DELEGATED HOUSEHOLDER DECISION

Item No.	Report of the Head of Development Management and Building Control		
Address:	79 HALFORD ROAD ICKENHAM		
Development:	Erection of a part single, part double storey extension to the rear/side, conversion of roof to habitable use to include, double hip to gable roof extension with 1no side and 1no rear dormer, roof lights and new gable end windows, following the demolition of existing conservatory and garage		
LBH Ref Nos:	43170/APP/2025/462		
Drawing Nos:	103 REV 4 E201 REV 4 E202 REV 4 102 REV 4 105 REV 2 101 REV 4 PP-13776506v1		
Date Plans received:	24-02-25	Date(s) of Amendments(s):	01-04-25
Date Application valid	24-02-25		01-04-25 01-04-25 01-04-25 01-05-25 01-04-25

Erection of a part single, part double storey extension to the rear/side, conversion of roof to habitable use to include, double hip to gable roof extension with 1no side and 1no rear dormer, roof lights and new gable end windows, following the demolition of existing conservatory and garage

DRAWING NO. 101
 PROJECT NO: 01
 DATE: 04/01/2025

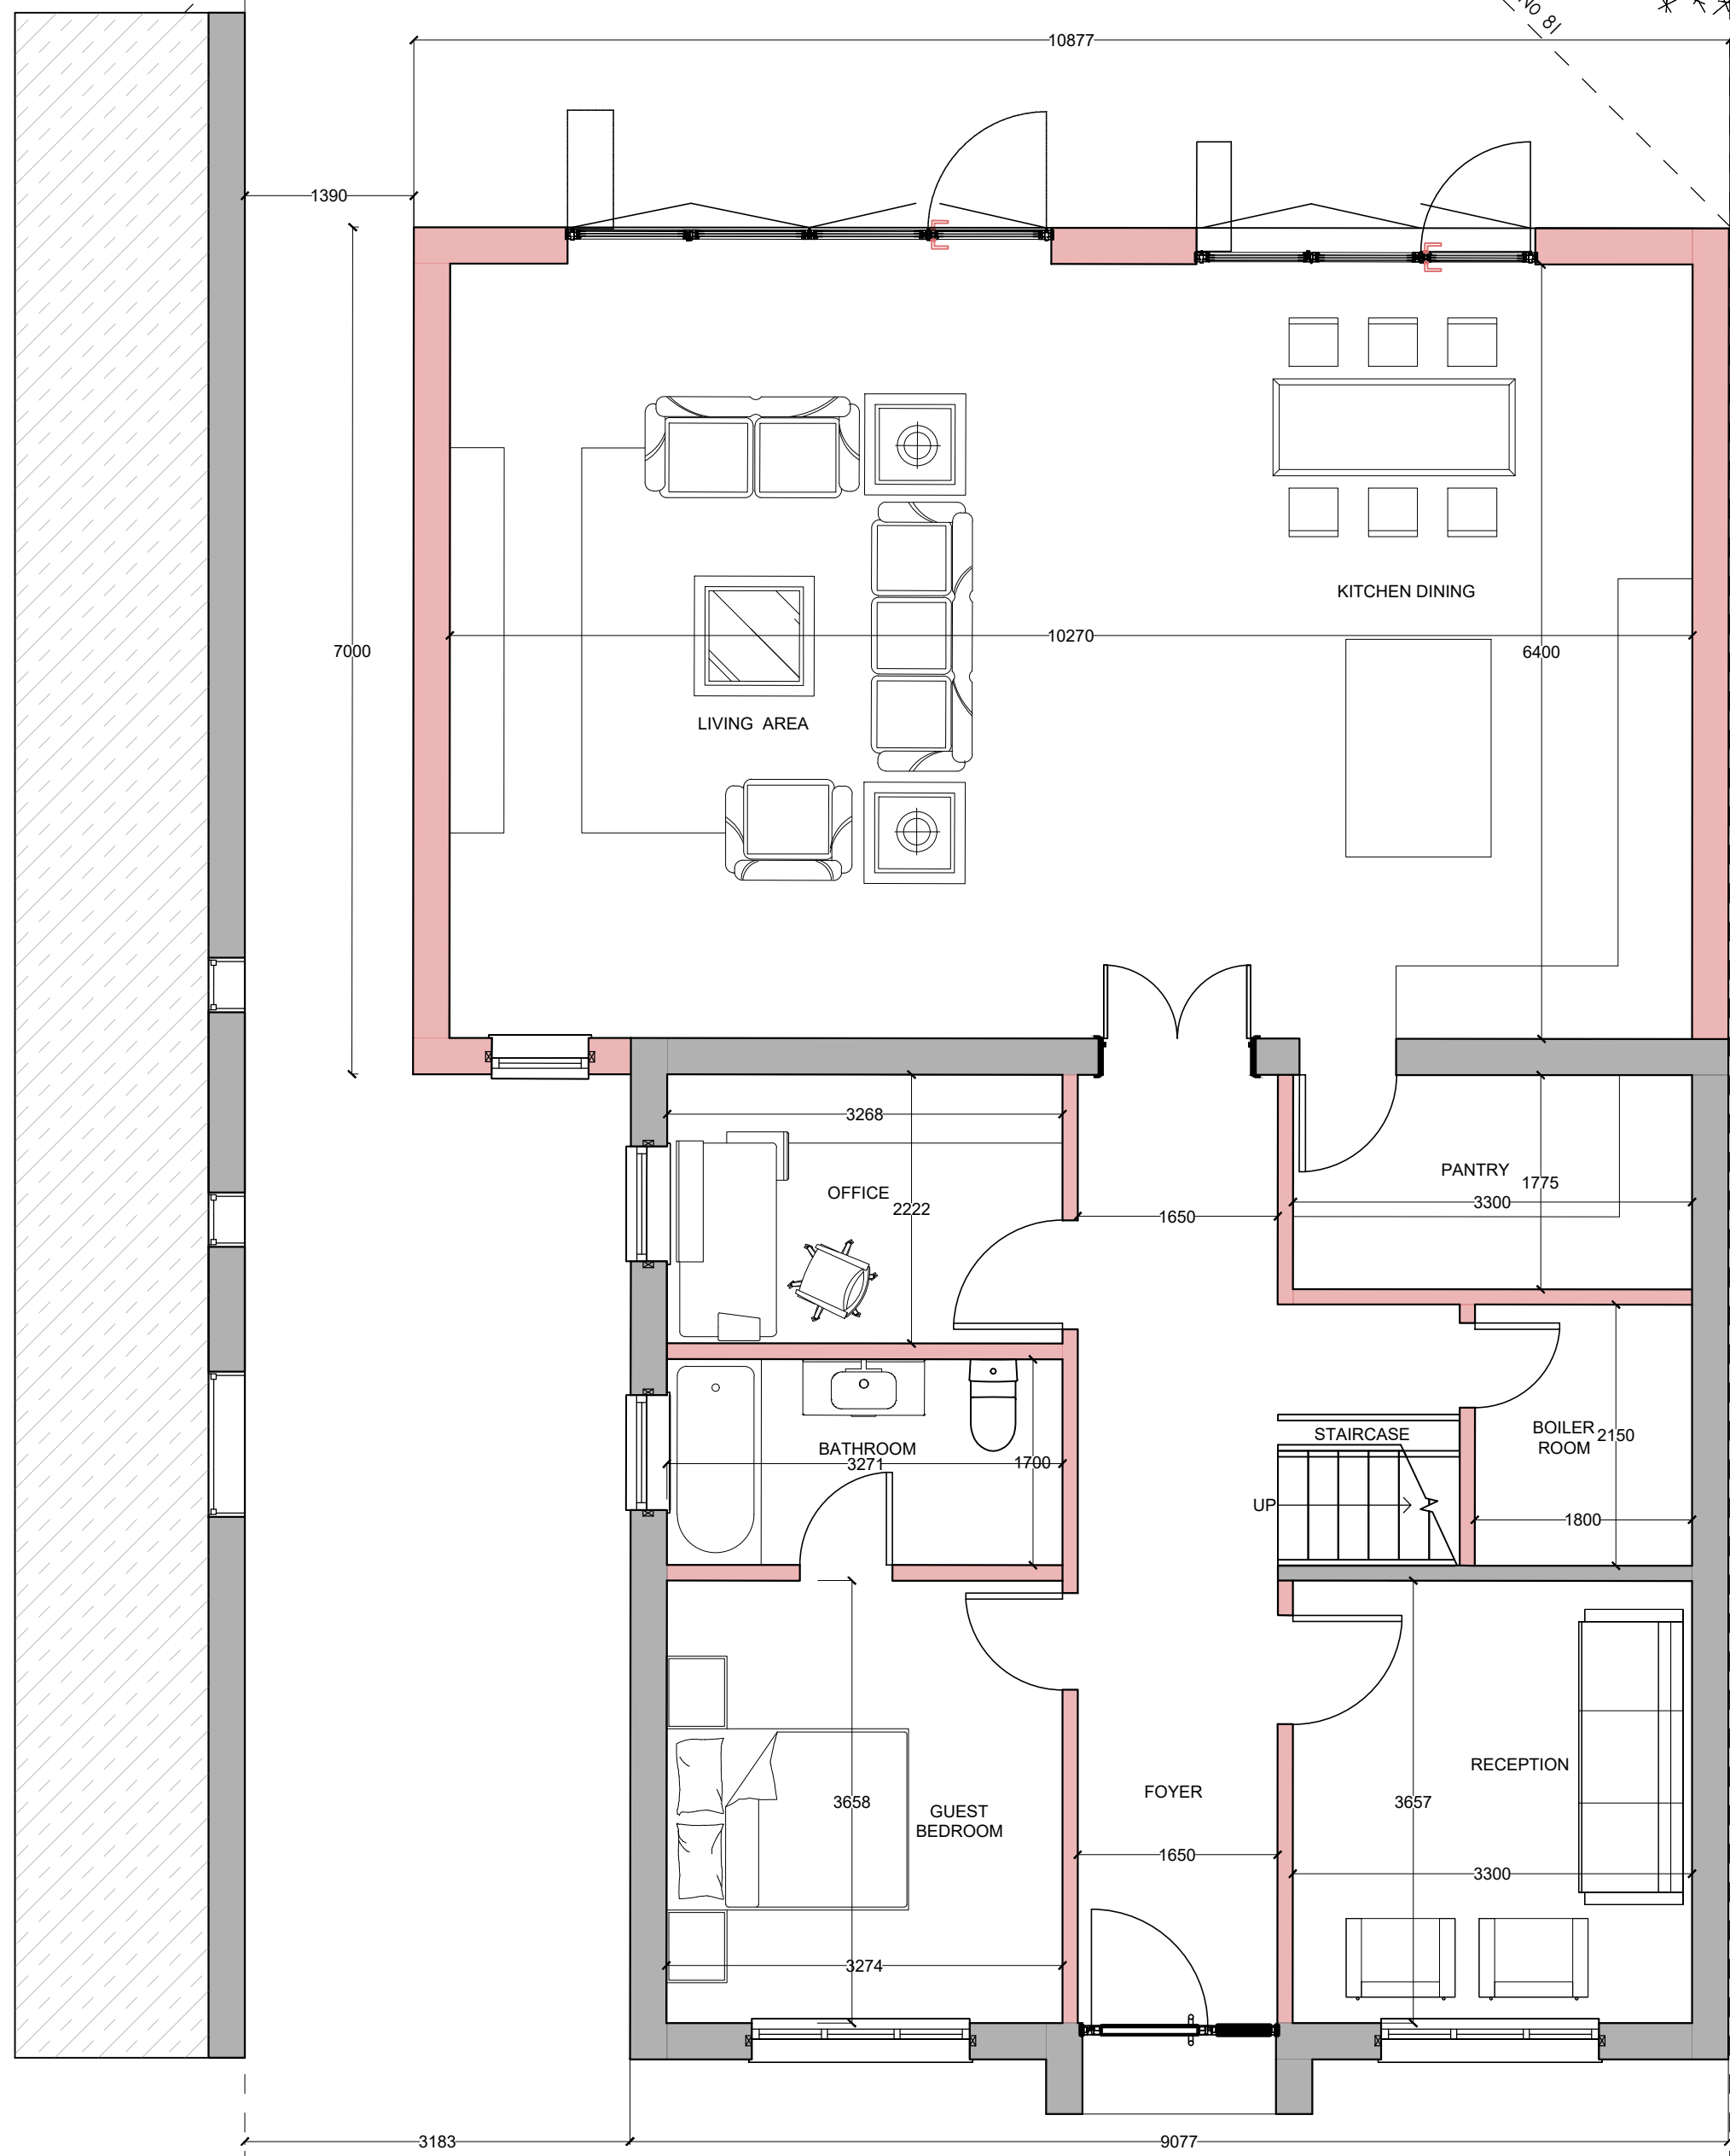
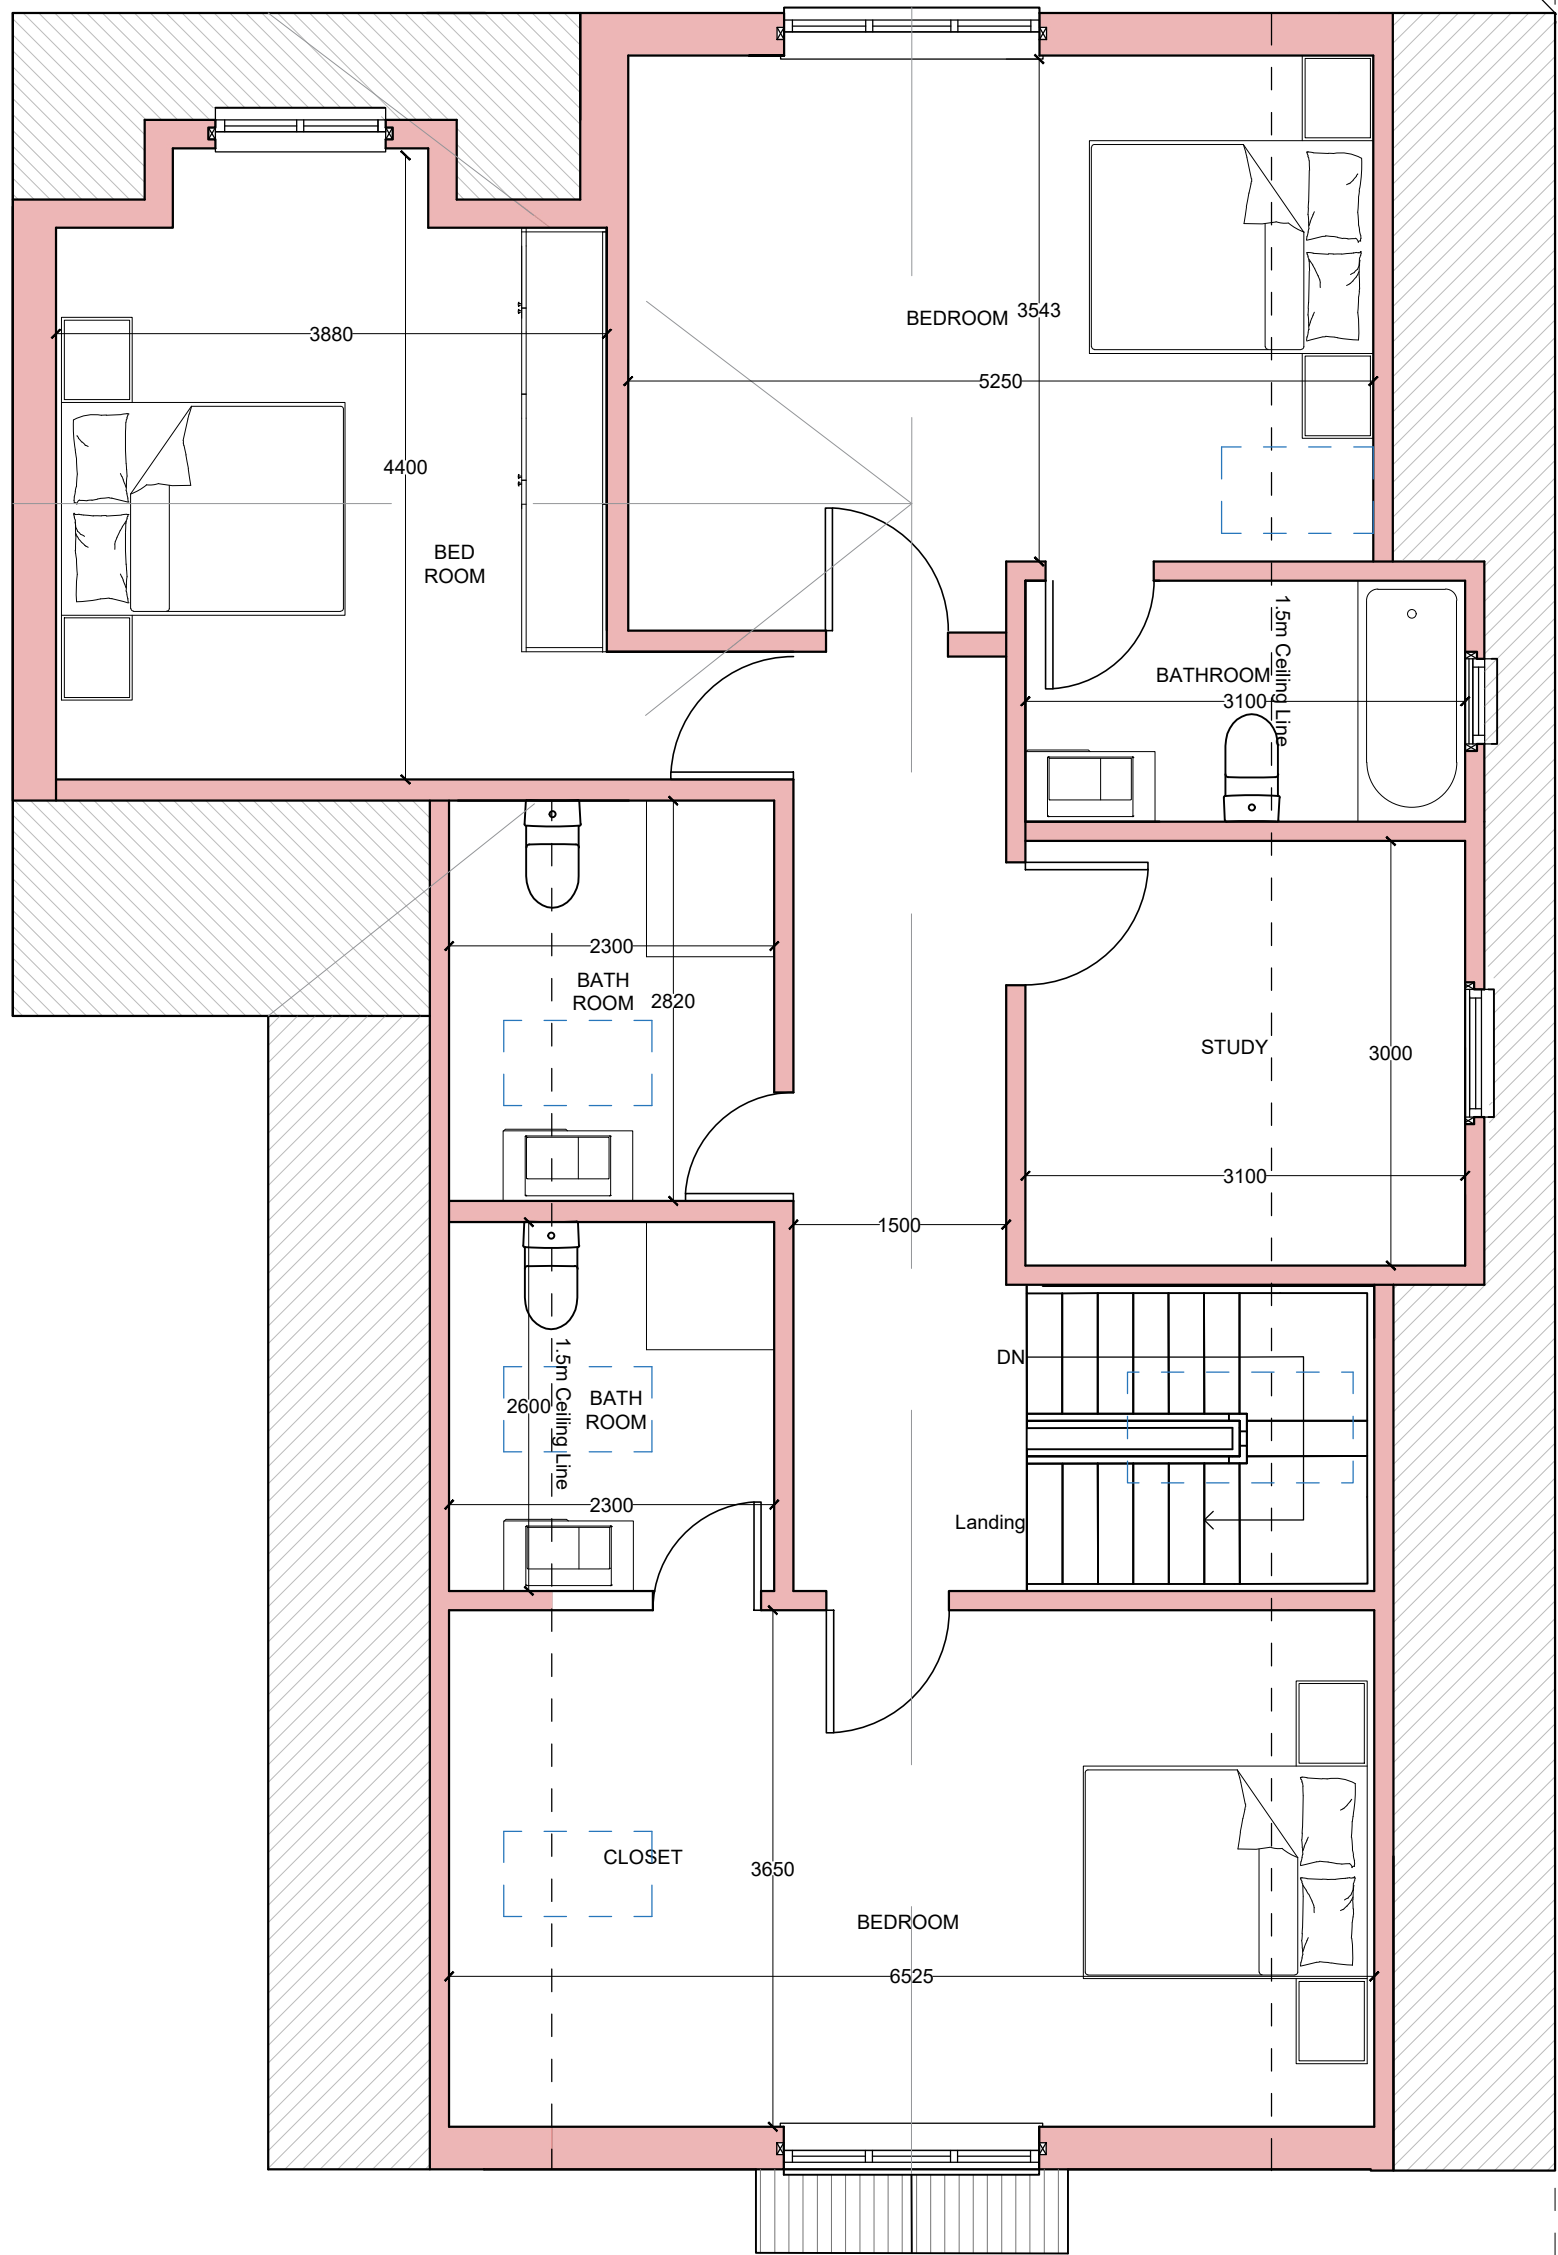
dwelling would maintain similar frontage as the existing property, and would be slightly behind the existing building line. To the rear the proposed rear elevation would be deeper than existing, however, offers a staggered depth when compared with neighbouring dwellings and would be comfortably sited outside of the 45 degree sight lines at ground and first floor.

Number 81 benefits from side windows at ground floor which according to planning history serve a shower room/utility. The proposed rear extension would not breach the 45 degree sight lines and would project approx. 3m past the rear elevation. The side windows would be conditioned to be obscured glazing and non-opening below 1.8m in the event of an approval. Taking these factors into account it is considered that the proposal would not adversely effect the amenities of neighbouring occupiers of No.81.
